Planning Officer:	David Easton
Planning Application Ref:	Y/91/17/OUT
Location:	Land at Bilsham Road, Yapton
Description of works:	Outline application for the development of up to 250 residential dwellings (Class C3) vehicular access, public open space, ancillary works and associated infrastructure. Departure from the Development Plan

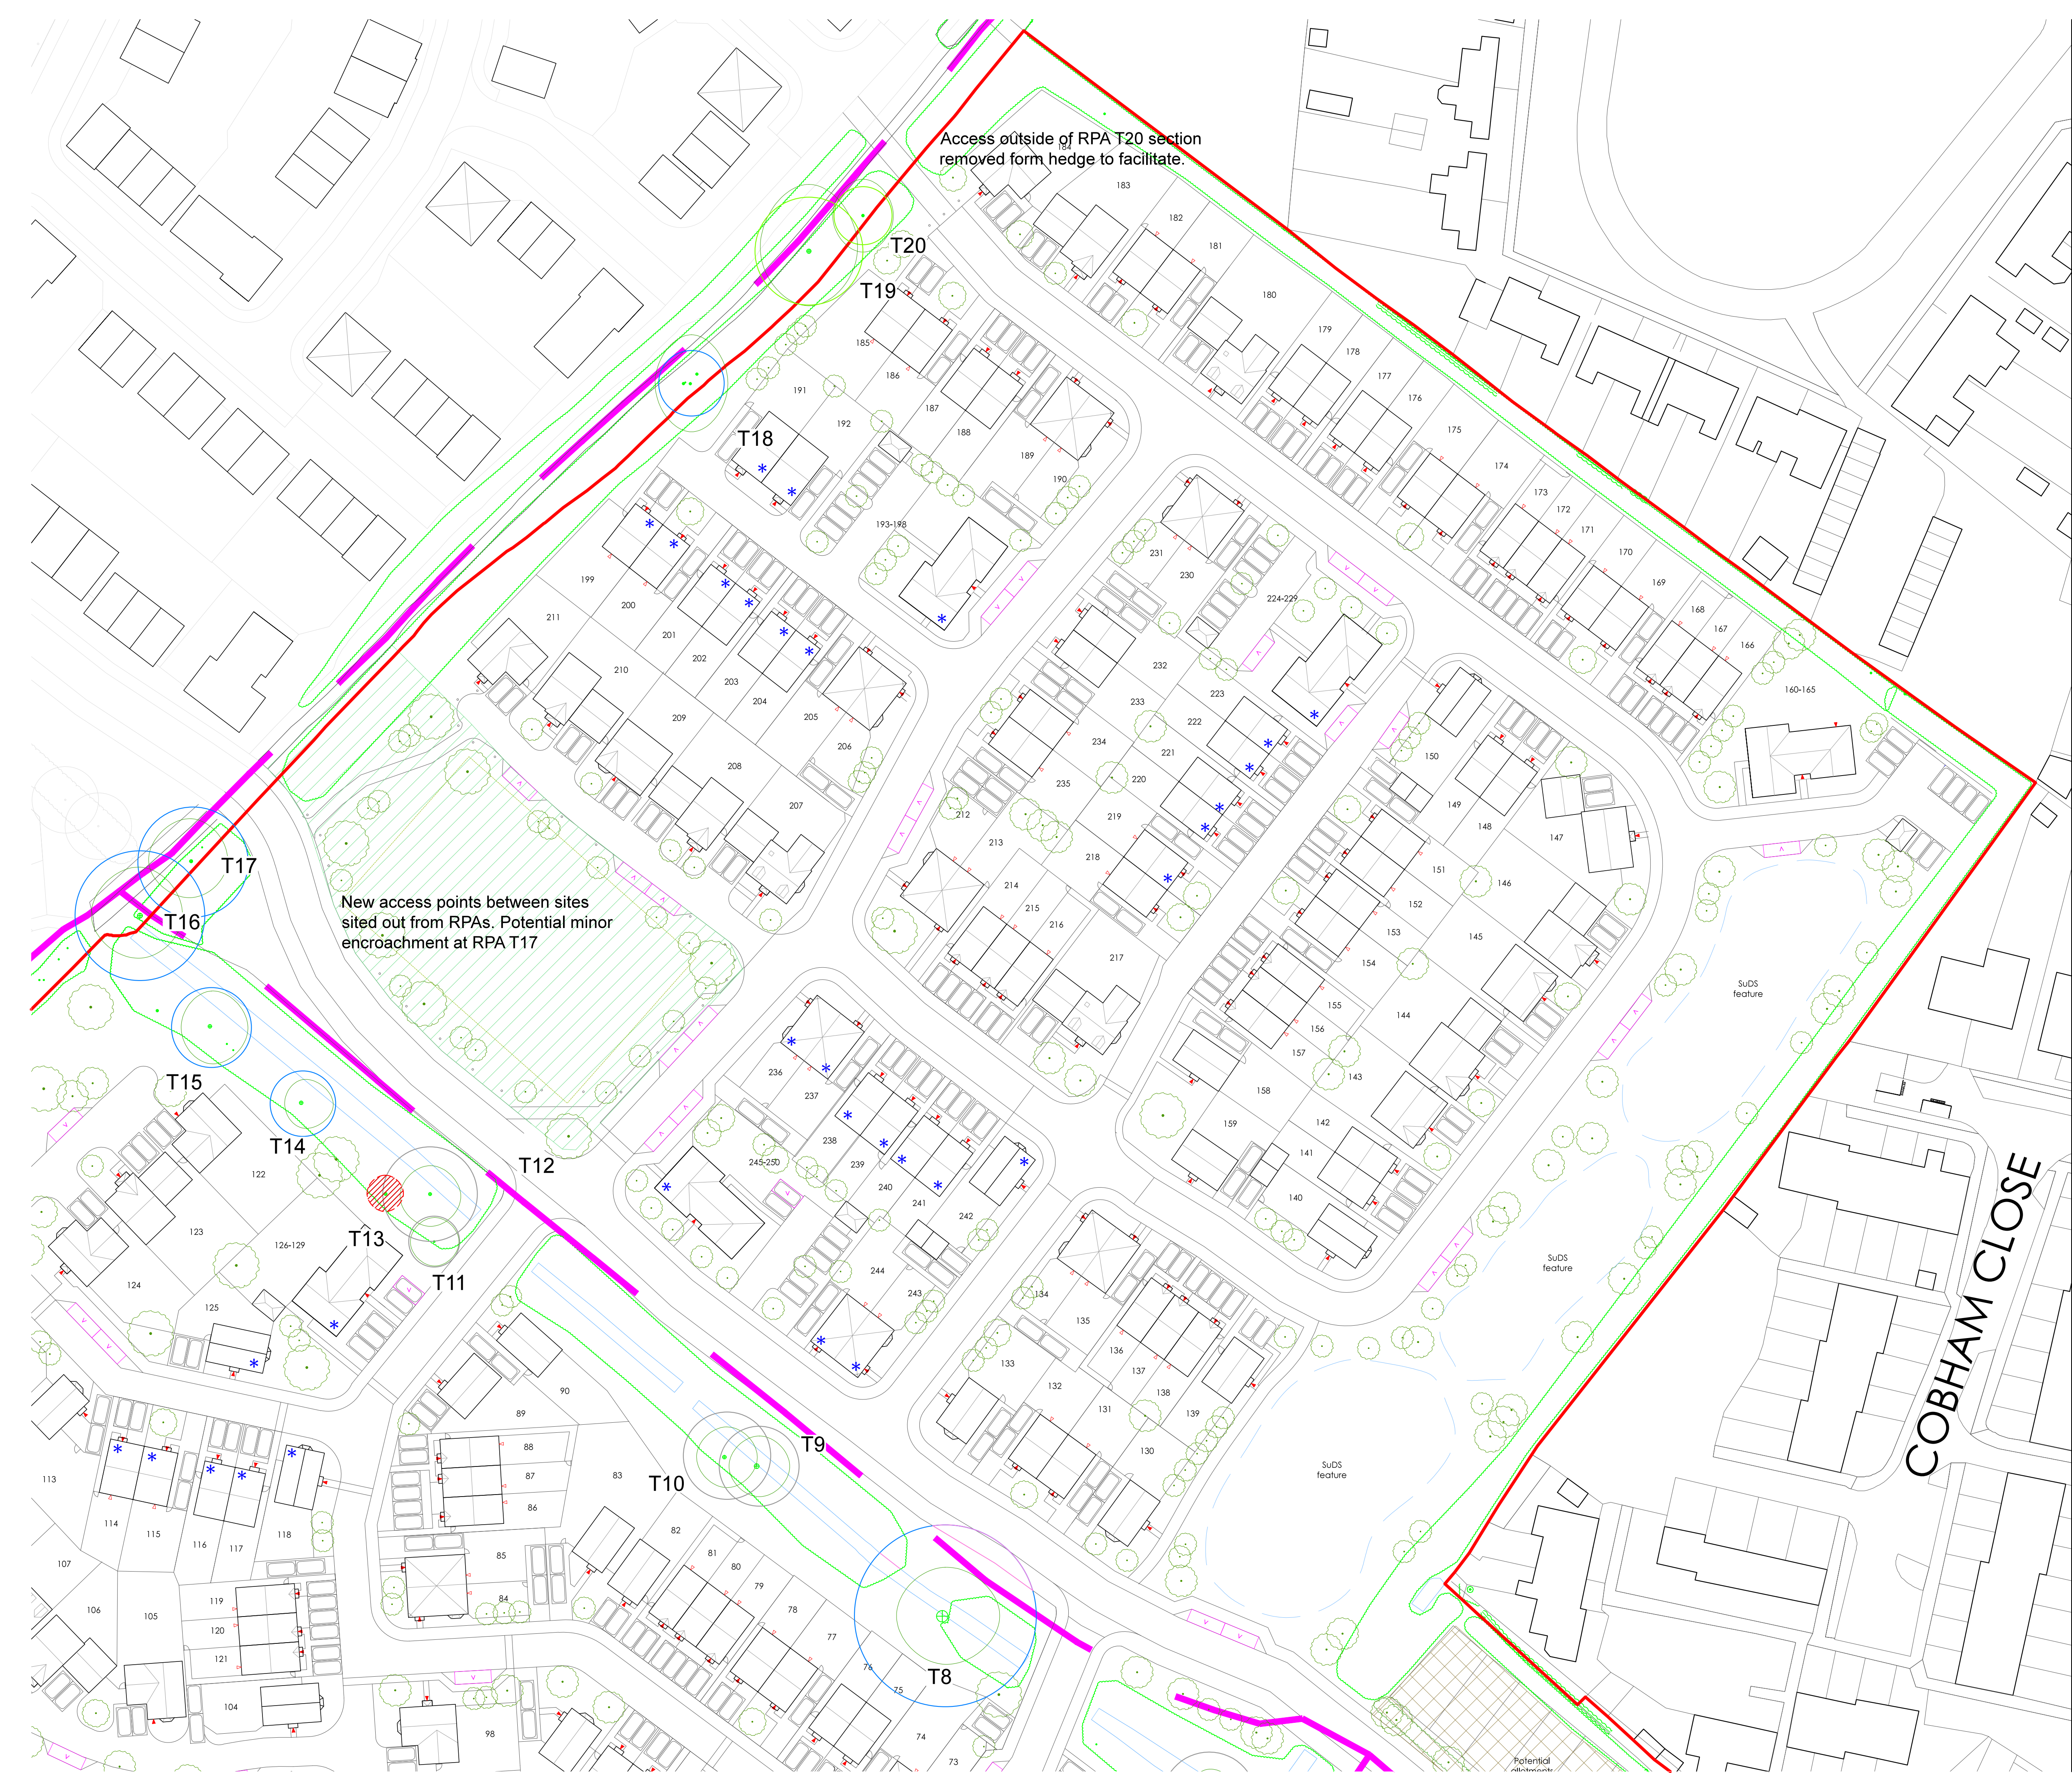
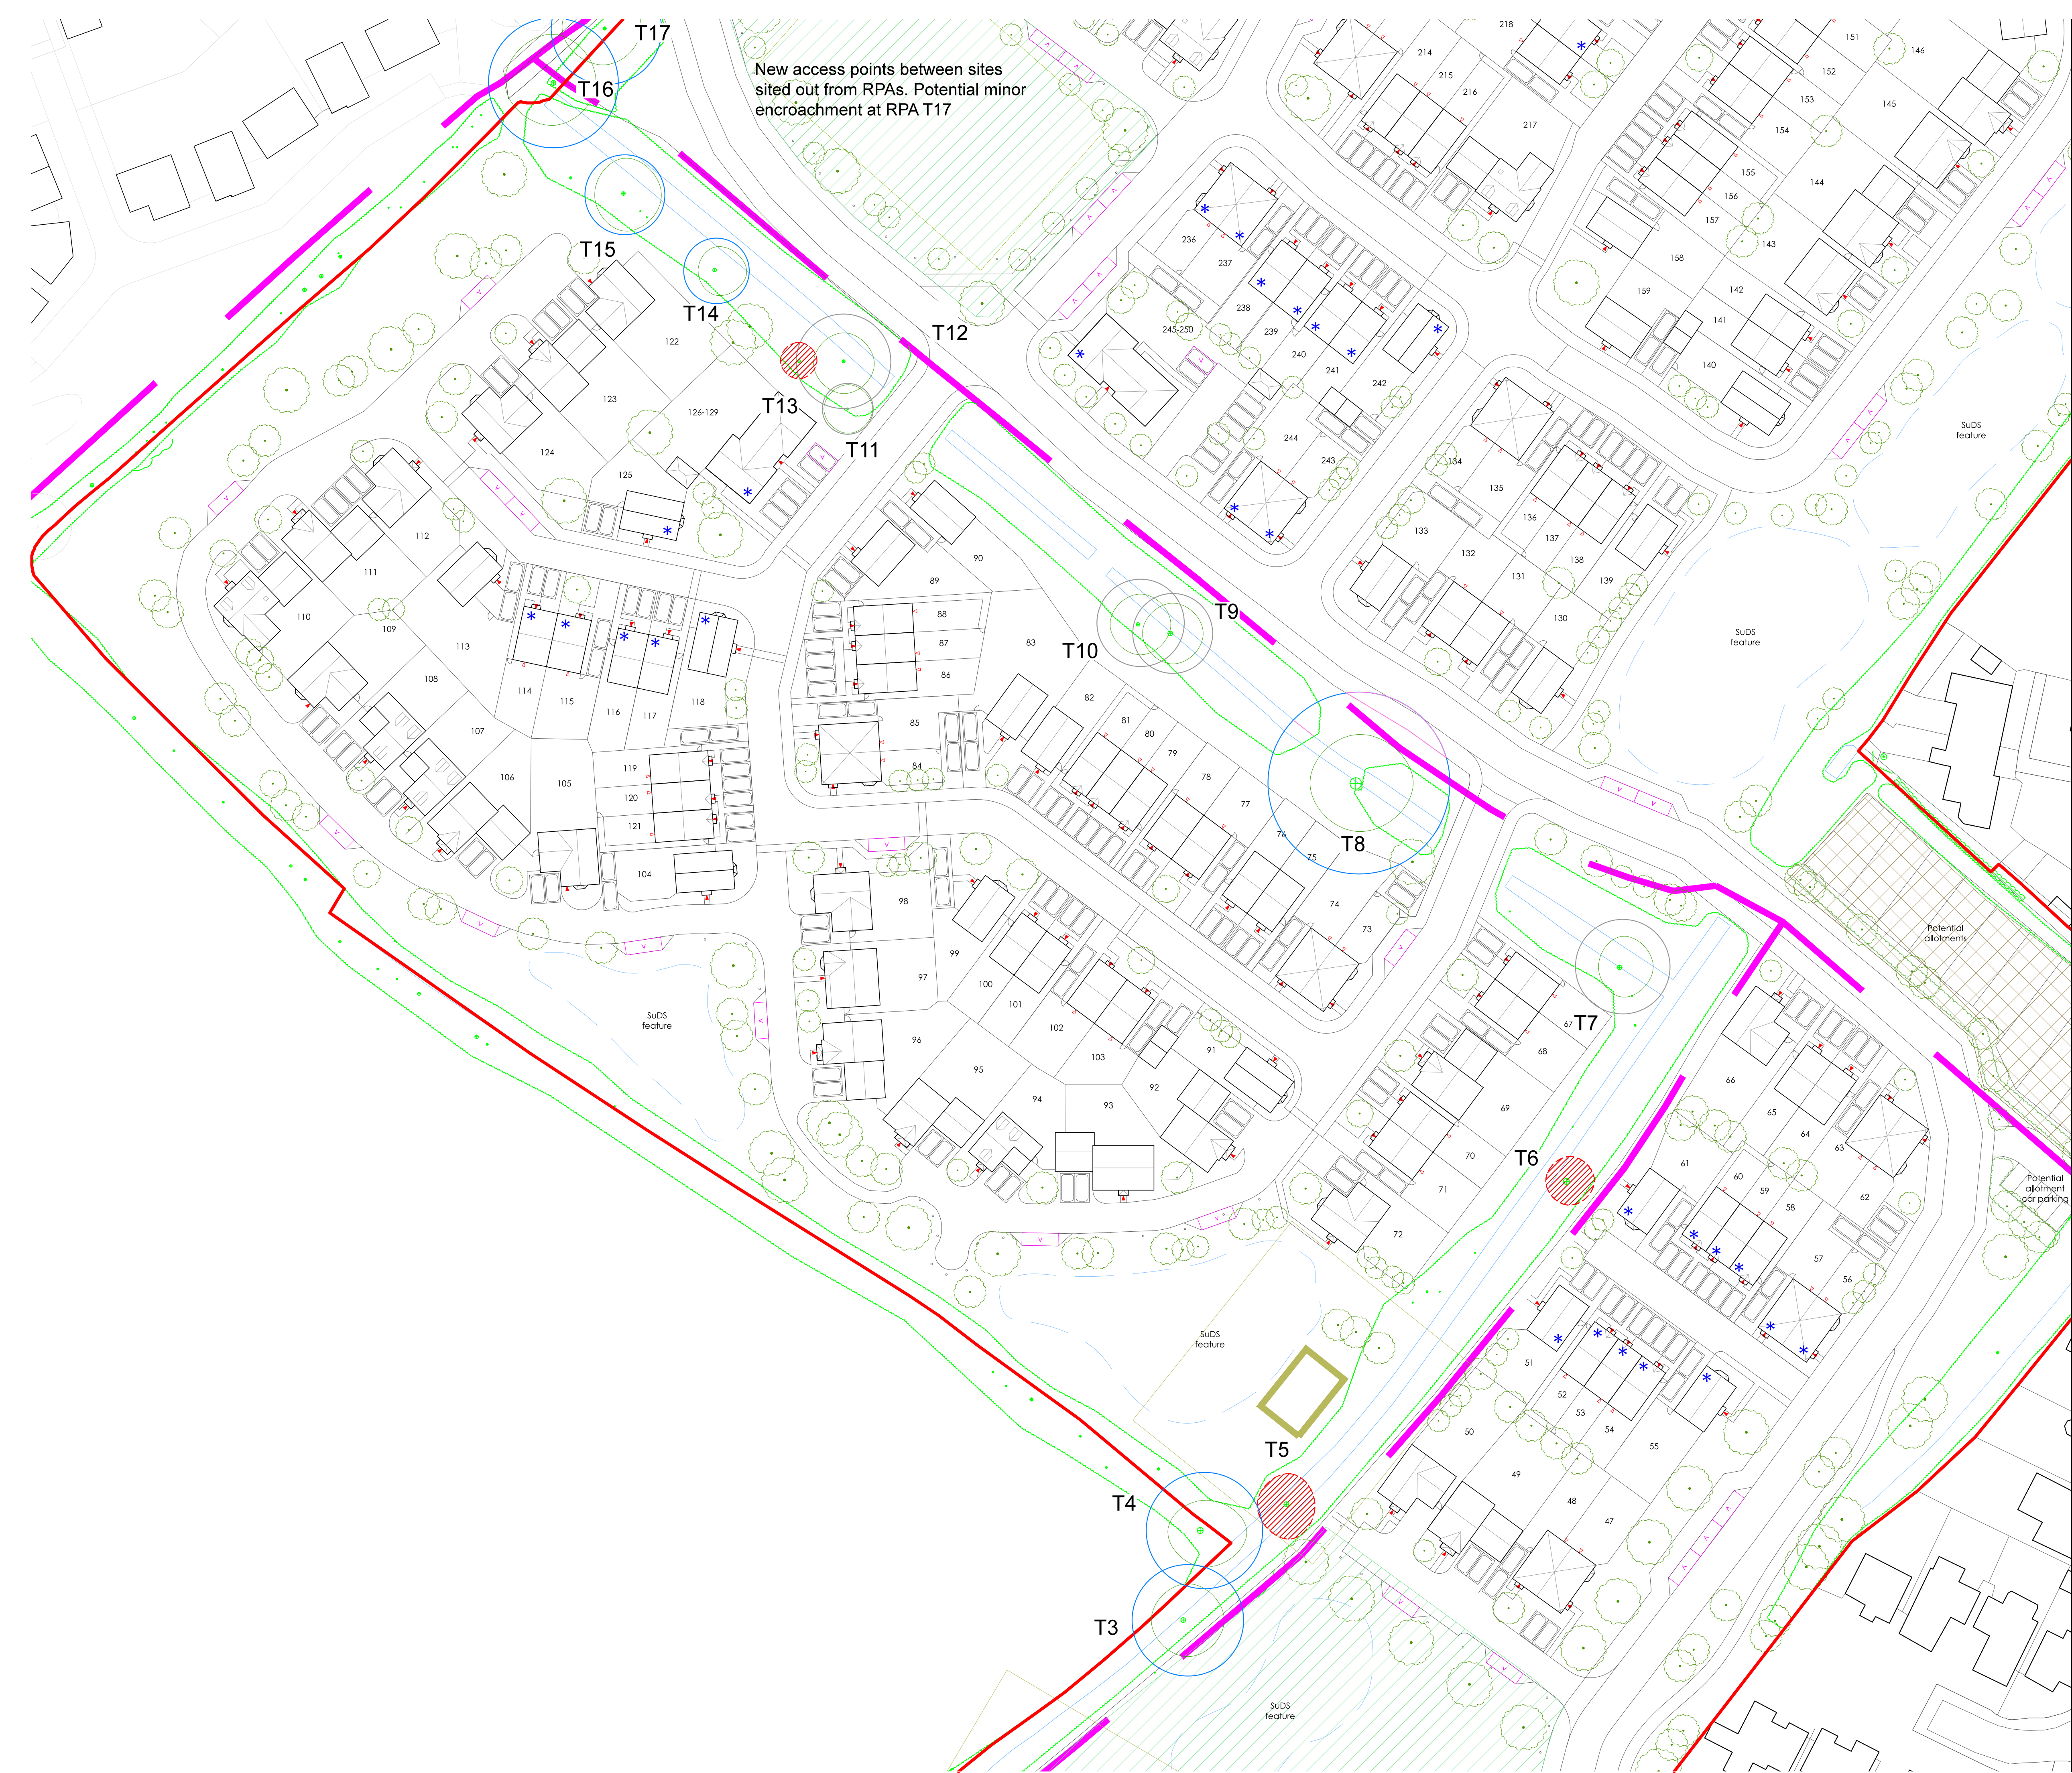
- The applicants employed the PJC Consultancy back in November 2017 to undertake a tree survey and then prepare an Arboricultural Impact Assessment (AIA) PJC/4699/17-02 R2. Tree Survey data is adequate at this stage and broadly accords with the requirements of BS5837:2012. I have referred to Illustrative detailed masterplan drg. 1244G.03 to assist with determining the accuracy of the Tree Constraints and Tree Retention Plans submitted by PJC with their AIA report. This allows me to gain a general understanding of how the plot layout and access routes relate to trees but is not specific enough for me to have full confidence they will be adequately respected and protected. **PJC Consultancy have submitted a revised Arboricultural Survey and AIA, ref. nos 3867/15/01 & /02 - Rev 04 and dated 13th and 14th March 2018 respectively. I have been asked to consider the amendments and provide comment. The supporting text within suggests a well-intentioned plan for significant trees on the site although it lacks the necessary detail to ensure their adequate protection and respect once development is underway.**

- I am pleased to see there is intent to retain the vast majority of recorded trees in harmony with the development, but I cannot be satisfied that this will be achievable until we receive a Tree Protection Plan (TPP) overlaying the final proposed site design layout, with supporting Arboricultural Method Statement (AMS) where RPA (Root protection area) incursion is anticipated - which I would expect to see submitted with a subsequent full planning application.

- At this outline stage, the indicative layout and access arrangements and the appointed arboriculturalist's general regard for significant trees existing on site are encouraging and I am in broad agreement with their survey information. That said, I am concerned that there appear to be notable omissions in respect of existing tree cover along several sections of the site perimeter (South, adjacent arable farmland – East, rear of The Millers – North, south of dwellings at Tack Lee Road). This may be deliberate as the proposed design does not at this stage suggest any direct interference with them but it is important to consider all trees whether they are on or off-site and within potential influencing distance, so as to inform the site layout design which may of course be subject to revision. Any omissions will need to be addressed and therefore included in the aforementioned TPP and AMS should this proceed to a full planning application. **Despite appearing in symbolic form on the Illustrative detailed masterplan drg. 1244G.03, significant trees located within the Southern site perimeter hedgerow were omitted from the tree survey schedule provided by PJC. They are of such dimensions and proximity as to be a material consideration and will require full consideration and appropriate levels of protection before any work can commence on site. I have determined that the majority of these merit a TPO. These trees have now been included in the tree survey schedule and so should be recognised in the anticipated TPP.**
